KITITAS COUNTY

MEMORANDUM

TO: All Staff
FROM: Public Works Review Team
DATE: July 16, 2020
SUBJECT: Johnston CB-20-00006
Tax Parcels: 950218 and 950219

Homesite 7-31 41 Hard Scrabble Lane

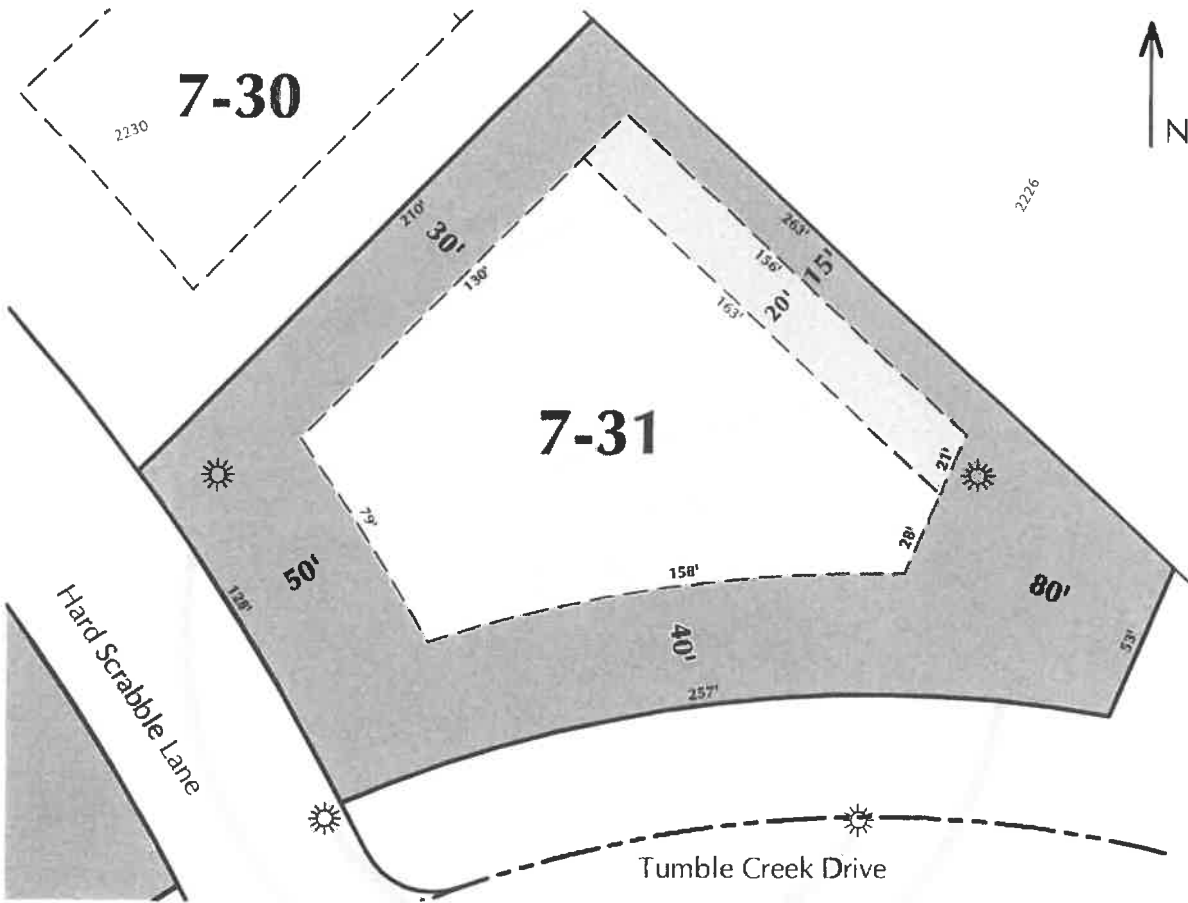
The tax parcels are located within Suncadia and fall under the Suncadia Development Agreement. The combination will use the current access at 41 Hard Scrabble Lane.

Any additional access would have to comply with Suncadia's road agreement.
